# CITY OF PORTLAND BUILDING PERMIT

Job ID: 2011-10-2519-CH OF USE

has permission to Change the Use & tenant fit up, from retail to Coffee Shop/Restaurant  
provided that the person or persons, firm or corporation accepting this permit shall comply with all of the provisions of  
the Statues of Maine and of the Ordinances of the City of Portland regulating the construction, maintenance and use of  
the buildings and structures, and of the application on file in the department.

Reference:  
New RTU and Added Roof Insulation  
Proposed Coffee Shop  
Space "A"  
9 Commercial Street  
Portland, Maine

**4** Roof Plan  
 1/16" = 1'-0"

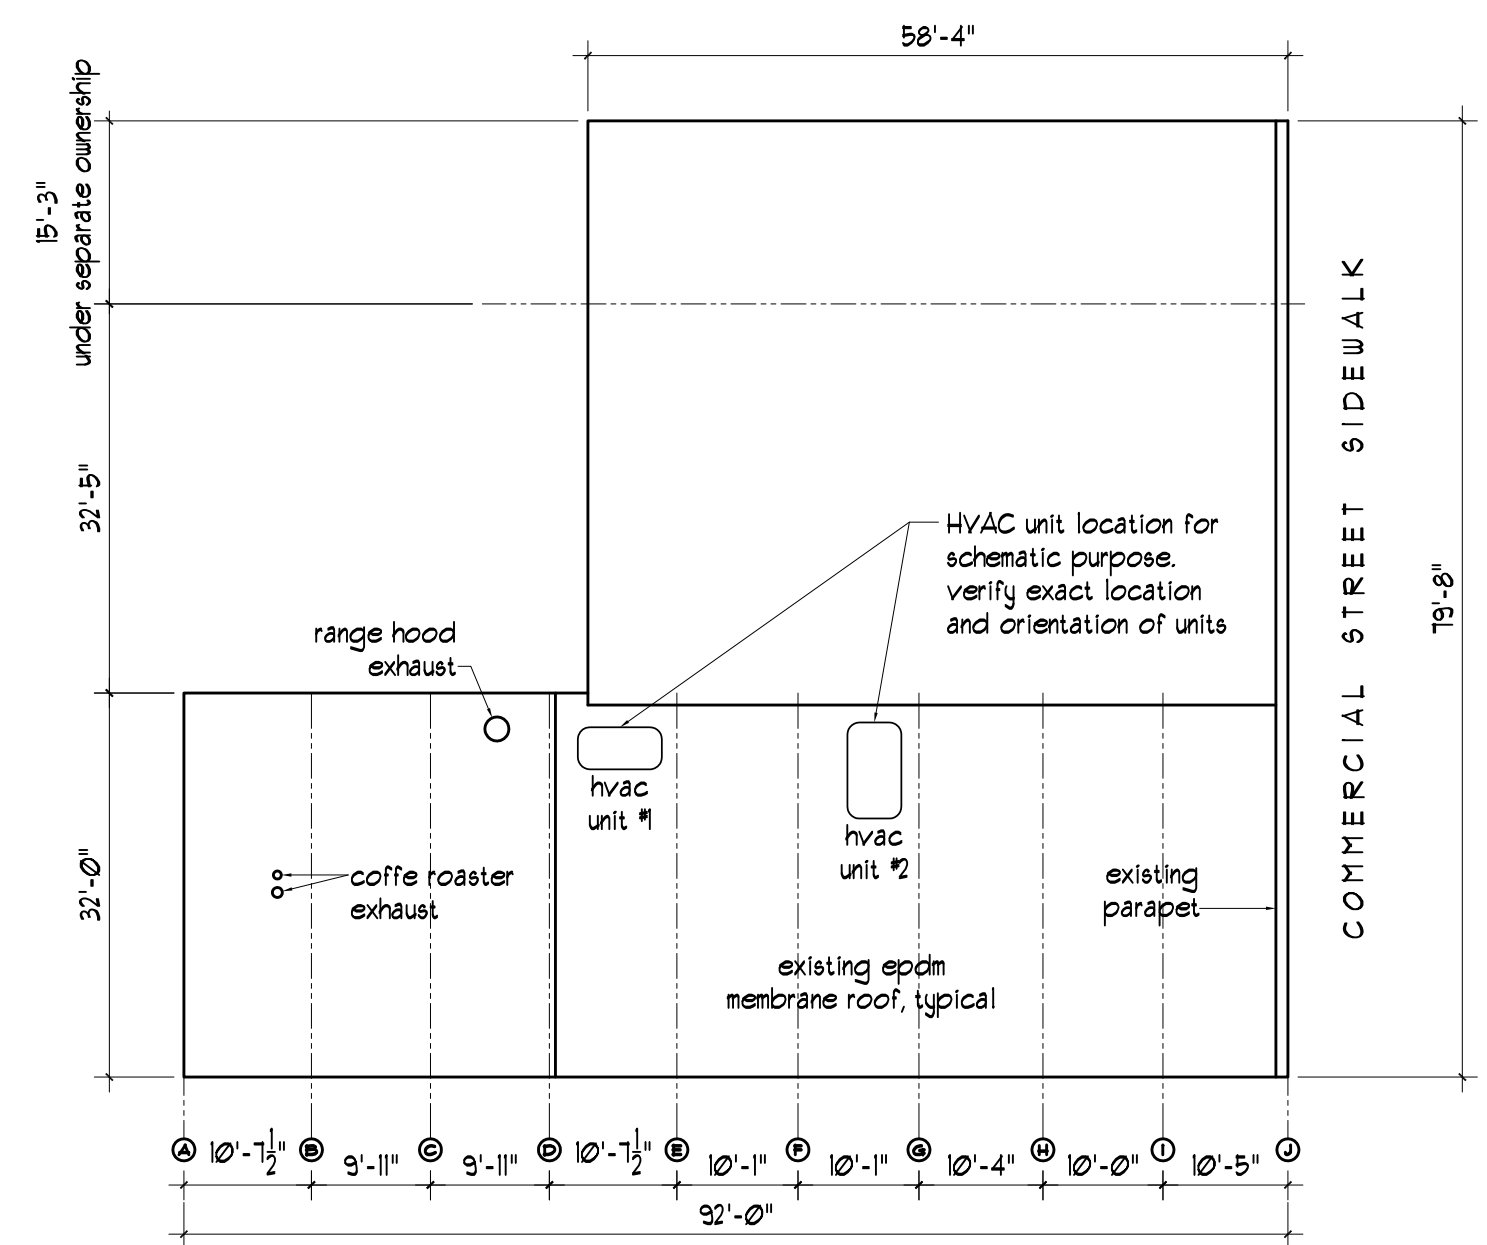
I have also reviewed the location and installation of the new RTU's shown on on the current documents for the project and have found that the trussed girders are capable of supporting the new RTU weight and snow loads. The new RTU's are to be located between girders "C" and "D" and between "D" and "E". The rafters below the new RTU's should be sistered with new 2x8 and fastened to the existing with (3) 16d nails at 8" typical. The critical location dimension that is to be held is from the north masonry bearing wall back to the RTU centers. This distance from the center of the RTU to the truss support/ north wall should not exceed seven feet.

building cross sections

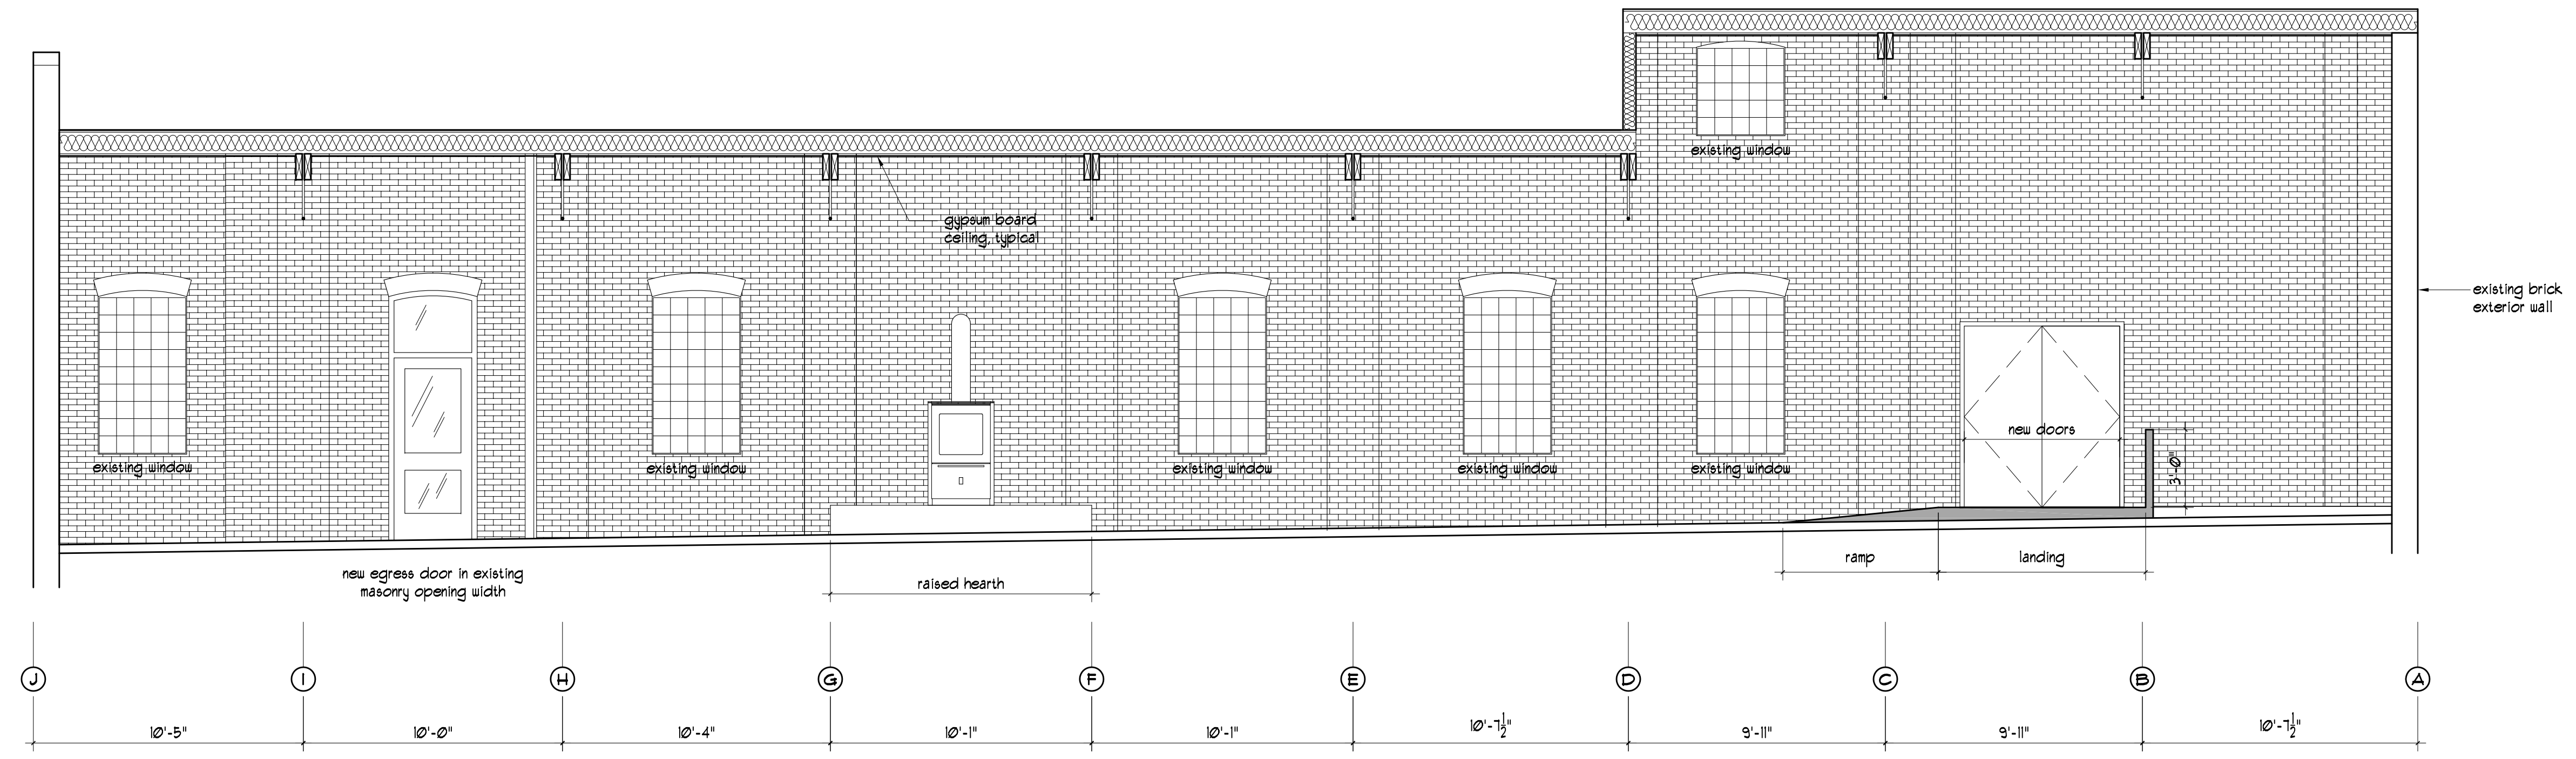
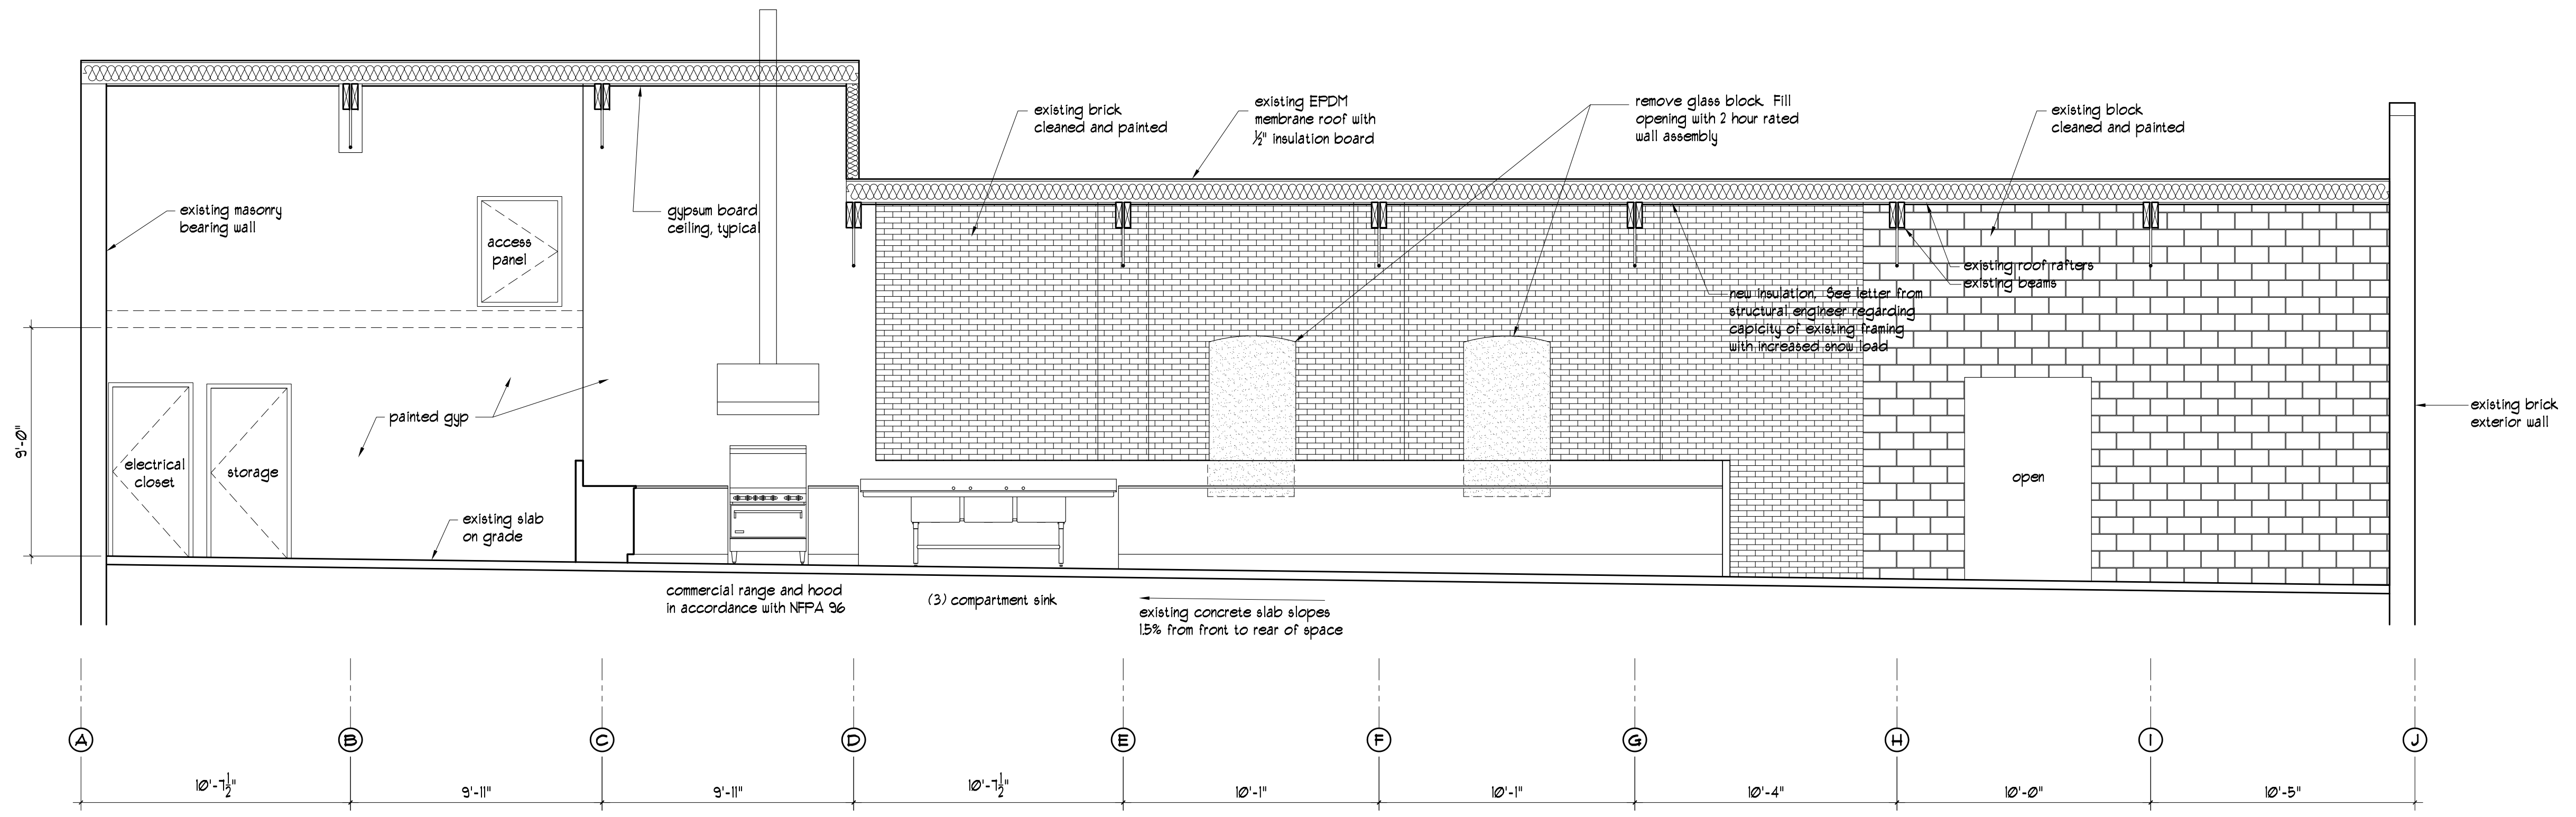
One connection at grid line "C" needs to be improved. The top chord of the truss needs to be strapped back to the double 2x10 rafter/brace that runs toward grid line "D". The top chord girder and the double 2x10 rafter at the middle of the truss span should be connected with a TS24 Simpson strap at each side of the double 2x10.
